Further assessment of trees adjacent to the A3 boundary

RHS Wisley, Surrey

J2002 - M25 J10 DCO further tree assessment

2nd July 2020

**highways england**

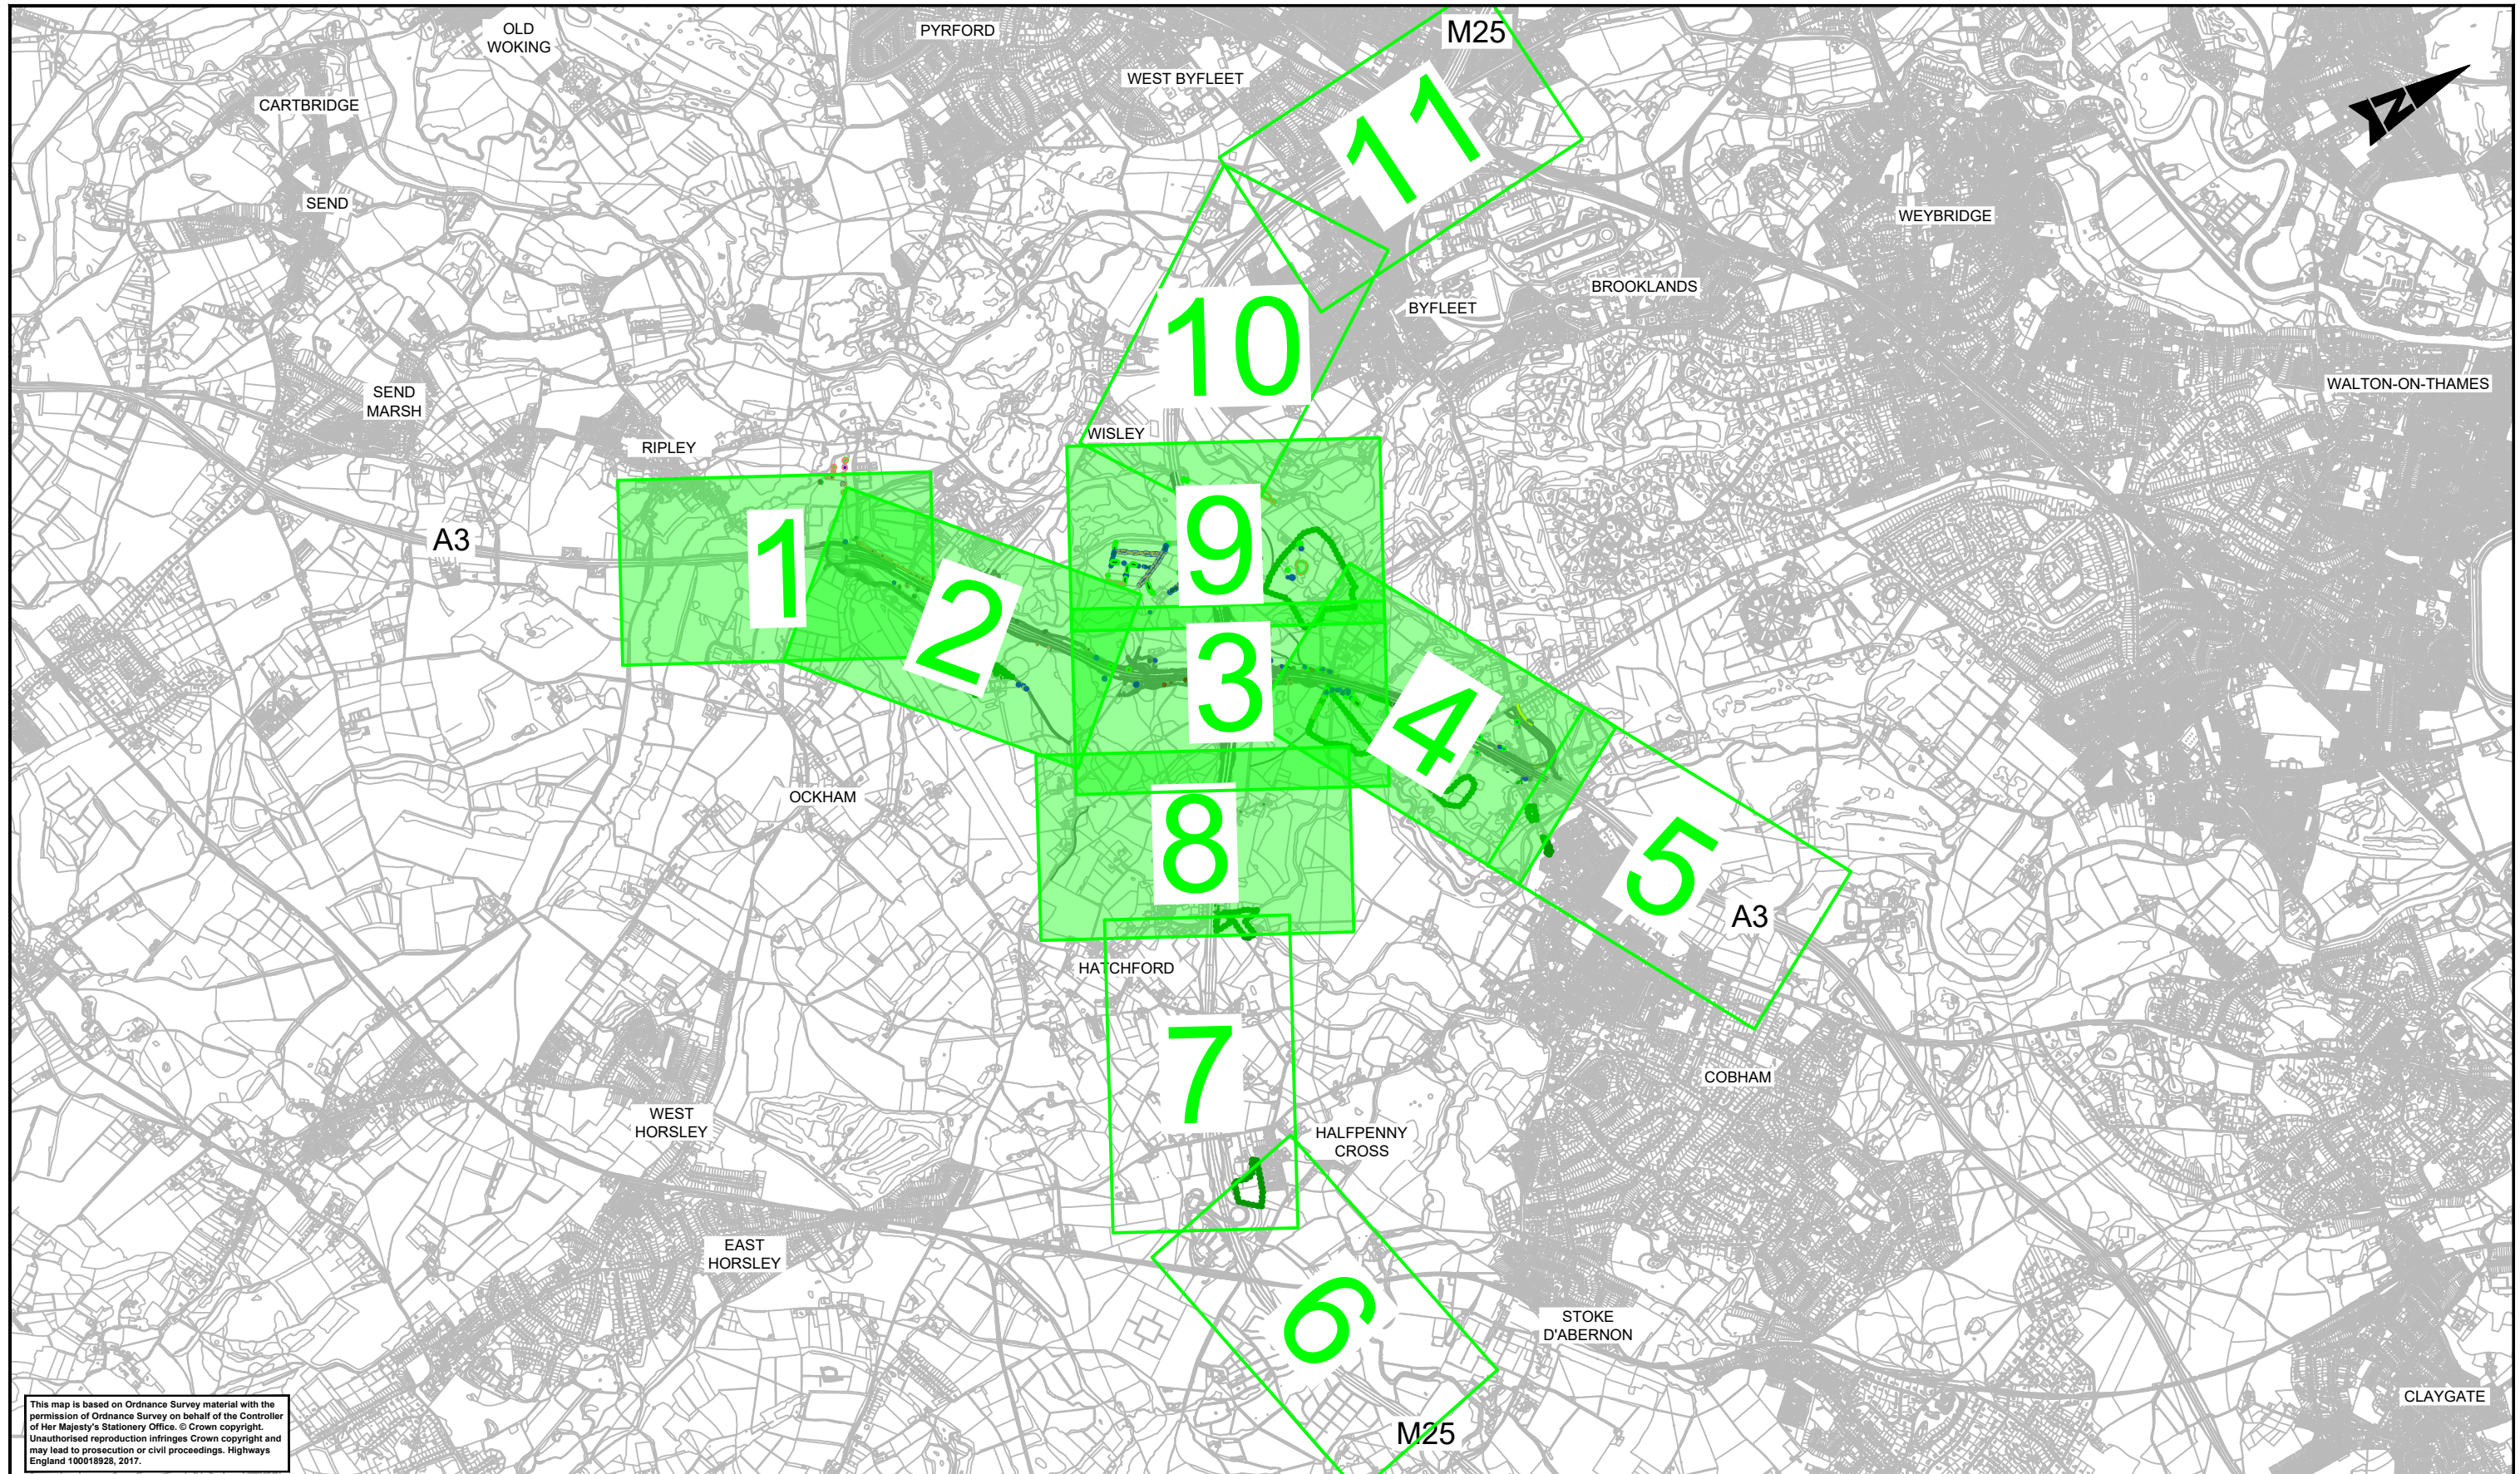
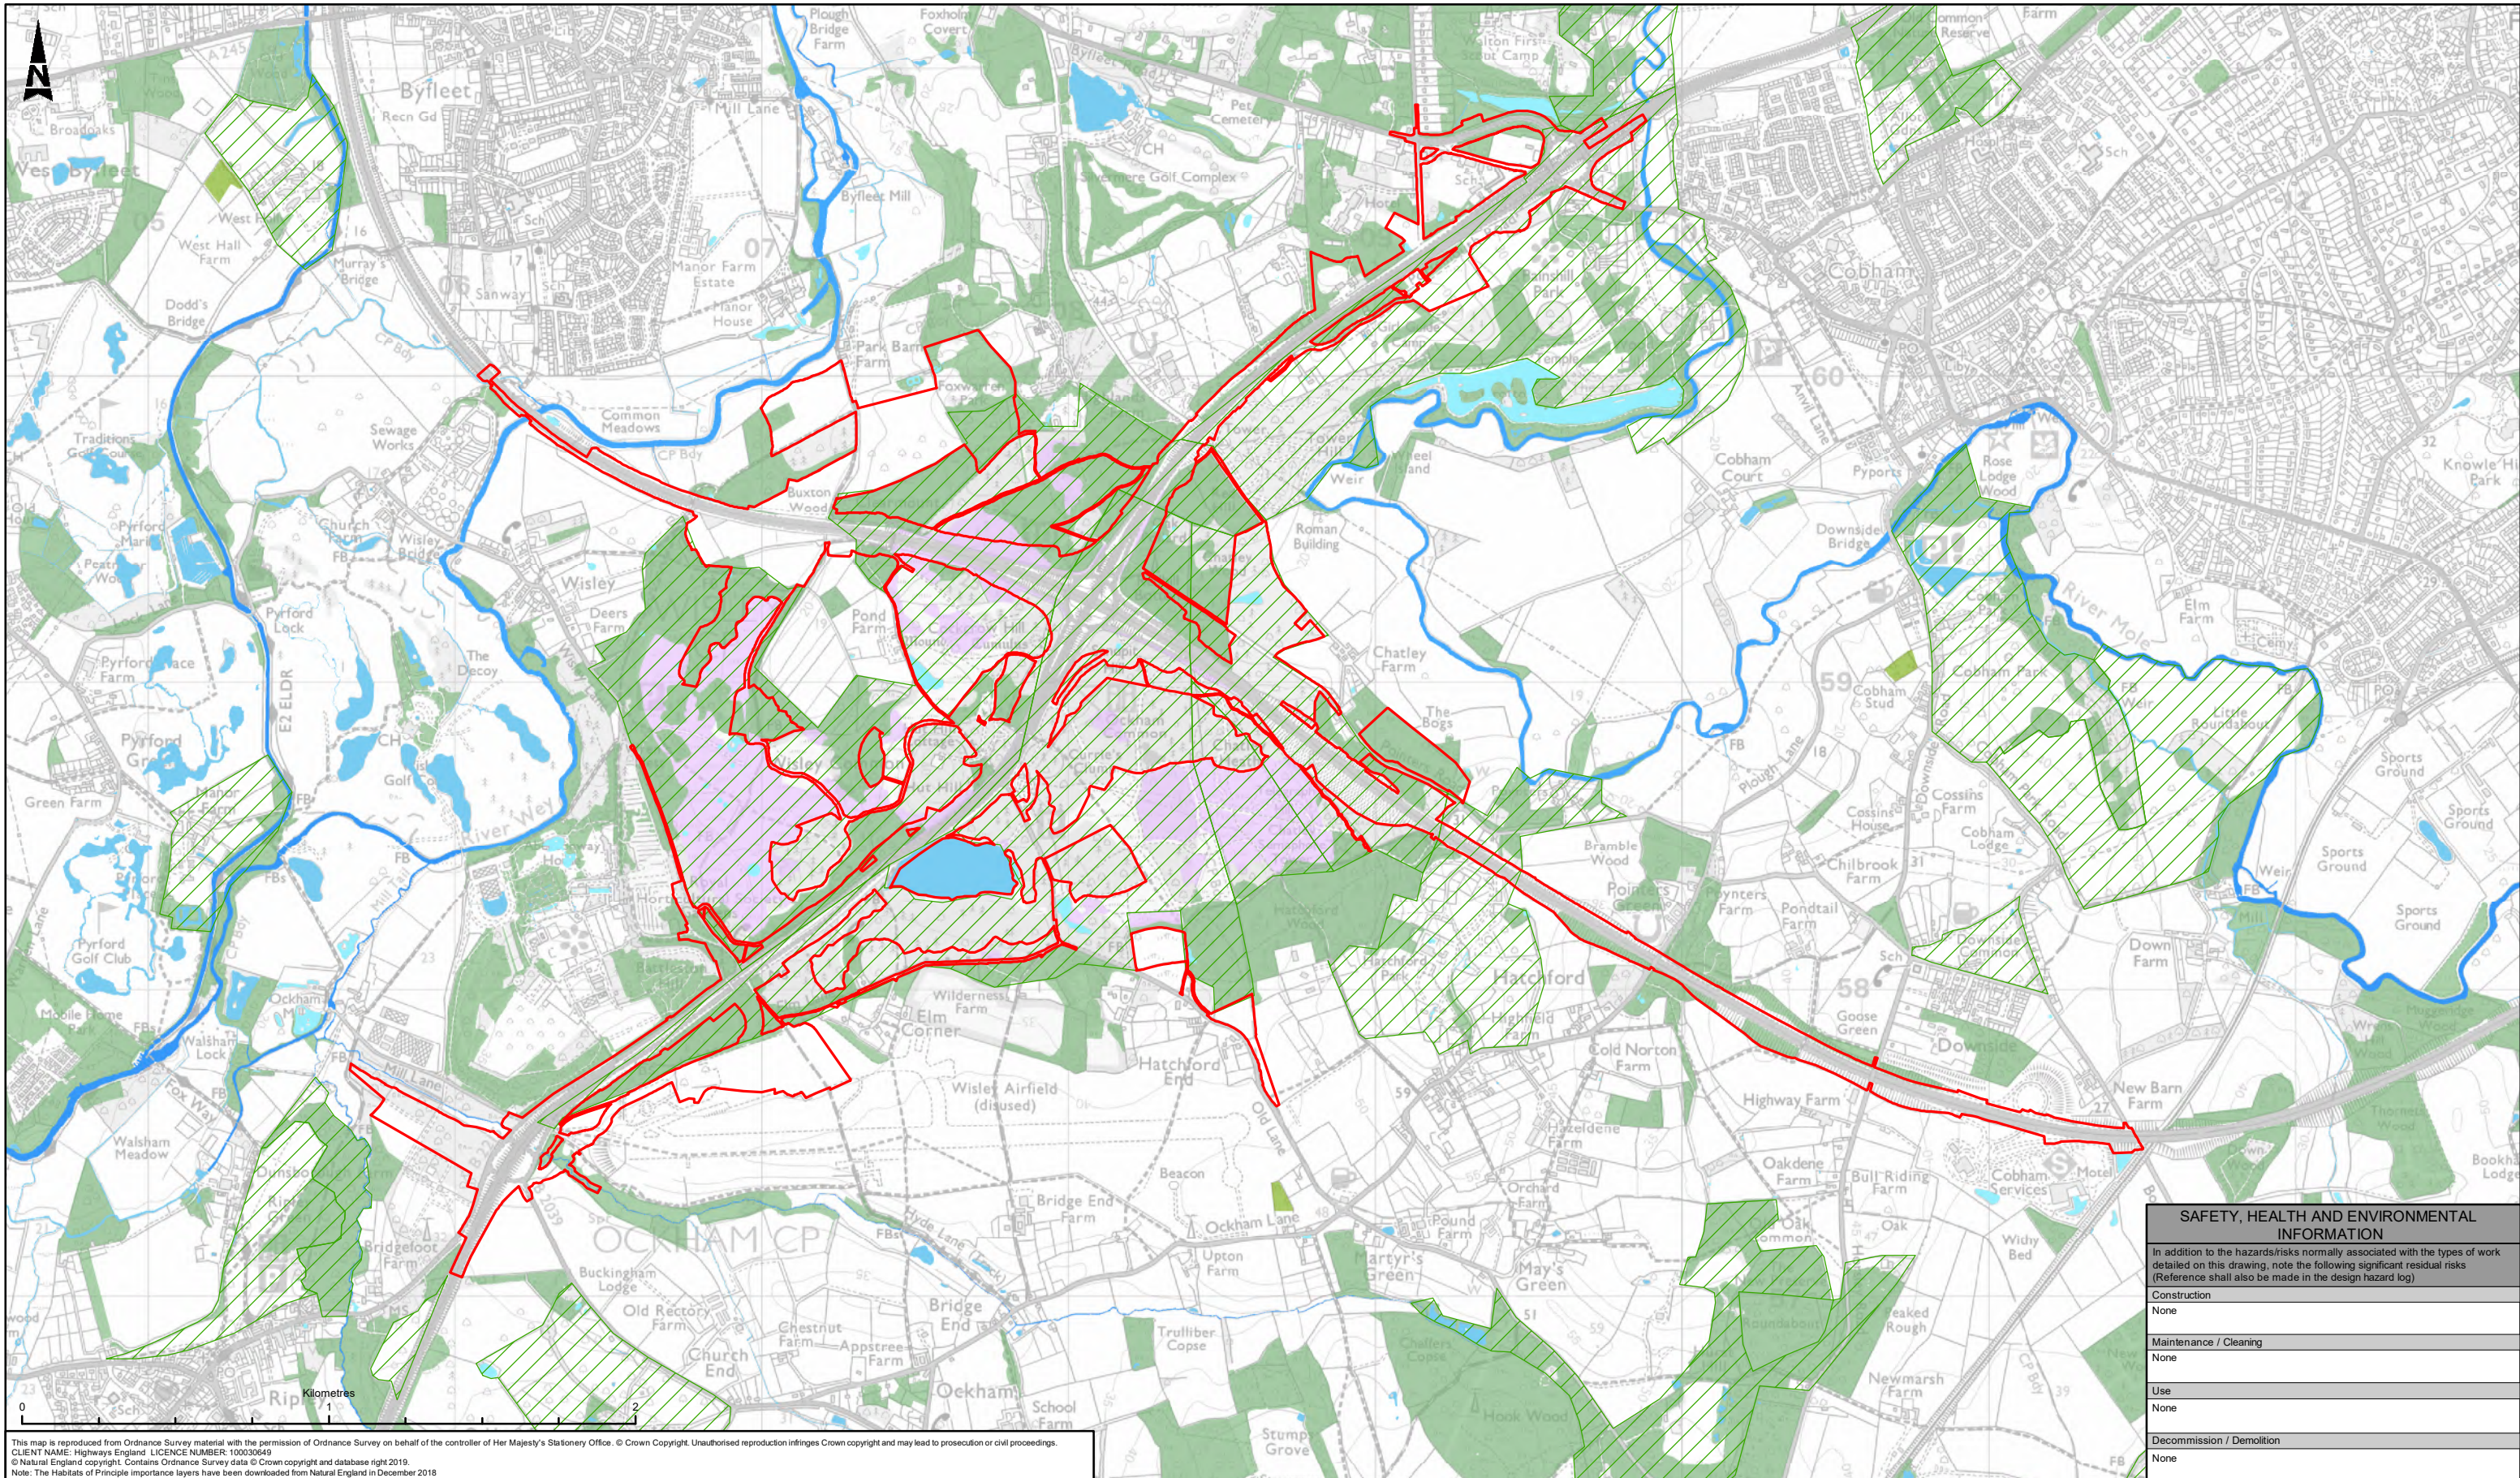
From my review of the HE survey and comparing it to the 44 trees that I identified as being at risk, I found that the HE survey failed to:

1. take any account of the heritage or financial value of any of the Wisley trees that could be adversely affected;
2. to follow the guidance in BS 5837 on respecting RPAs;
3. to identify 16 trees (1, 2, 4–17) as impacted through the Wisley Lane changes; and,
4. possibly account for a further 15 trees (18–22, 24, 29, 31–33, 35, 37, 40–42) that could be adversely affected and may also have been missed from the HE survey.

I concluded that my plan BT1 in Appendix 1 is a reliable record of trees that could be affected, whereas the HE survey is demonstrably not.

From my assessment in my report of 17th April 2020 (Let1-170420-JB), HE has not taken any account of the heritage or financial value of any of the Wisley trees that could be adversely affected. Furthermore, that assessment failed to follow the guidance in BS 5837 on respecting RPAs, and it certainly failed to identify 16 trees (1, 2, 4–17) as impacted through the Wisley Lane changes. Additionally, because of lack of clarity in the HE data allowing a positive identification, there is also possibly up to a further 15 trees (18–22, 24, 29, 31–33, 35, 37, 40–42) that could be adversely affected and may also have been missed from the HE survey.

In summary, plan BT1 in Appendix 1 is a reliable record of trees that could be affected, whereas the HE survey is demonstrably not.
